Sheila and Jane Pumfrey Nov 12th 2025 (Fire and pollution concerns)

Fire risks and lack of clarity

Figure 2.4: Wind Rose for North Clifton, Nottinghamshire

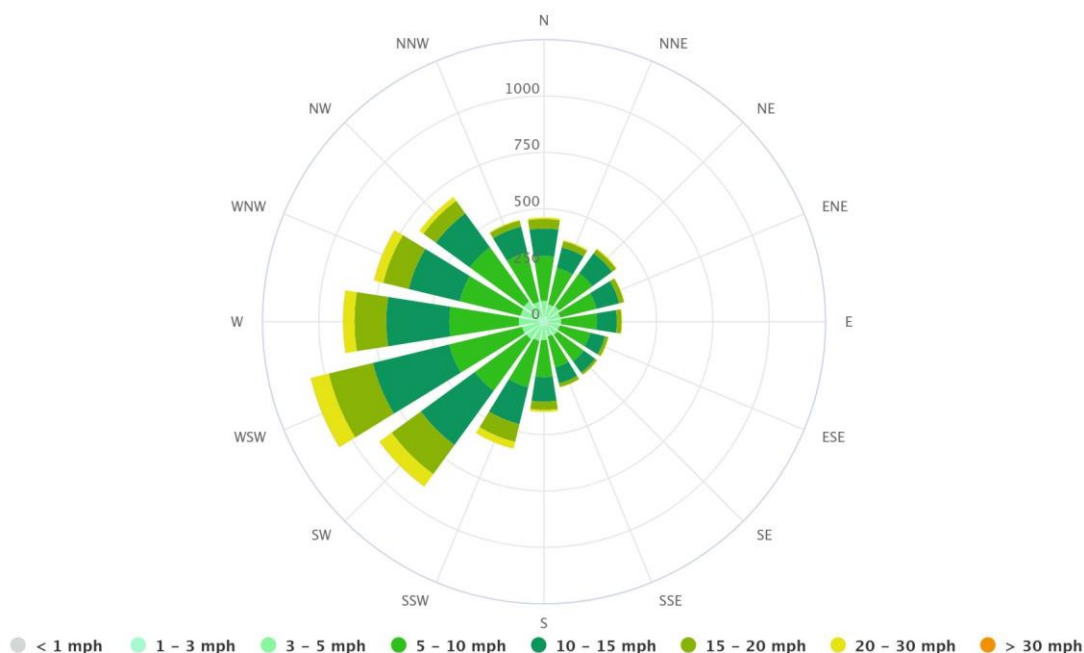
Finally, when the suitability of the Eastern BESS site is questioned, in response to our last questions, the developers reassure us that prevailing winds blow from the West – so not towards the nearby reservoir. Apart from this very obvious overly simplistic view, after reviewing detailed weather data, we can confirm that winds blow from the East approximately 9% of the time. Are we truly prepared to rely on the wind blowing from the “right” direction for such an important issue of public safety? We believe this to be an inadequate and dangerous assumption.
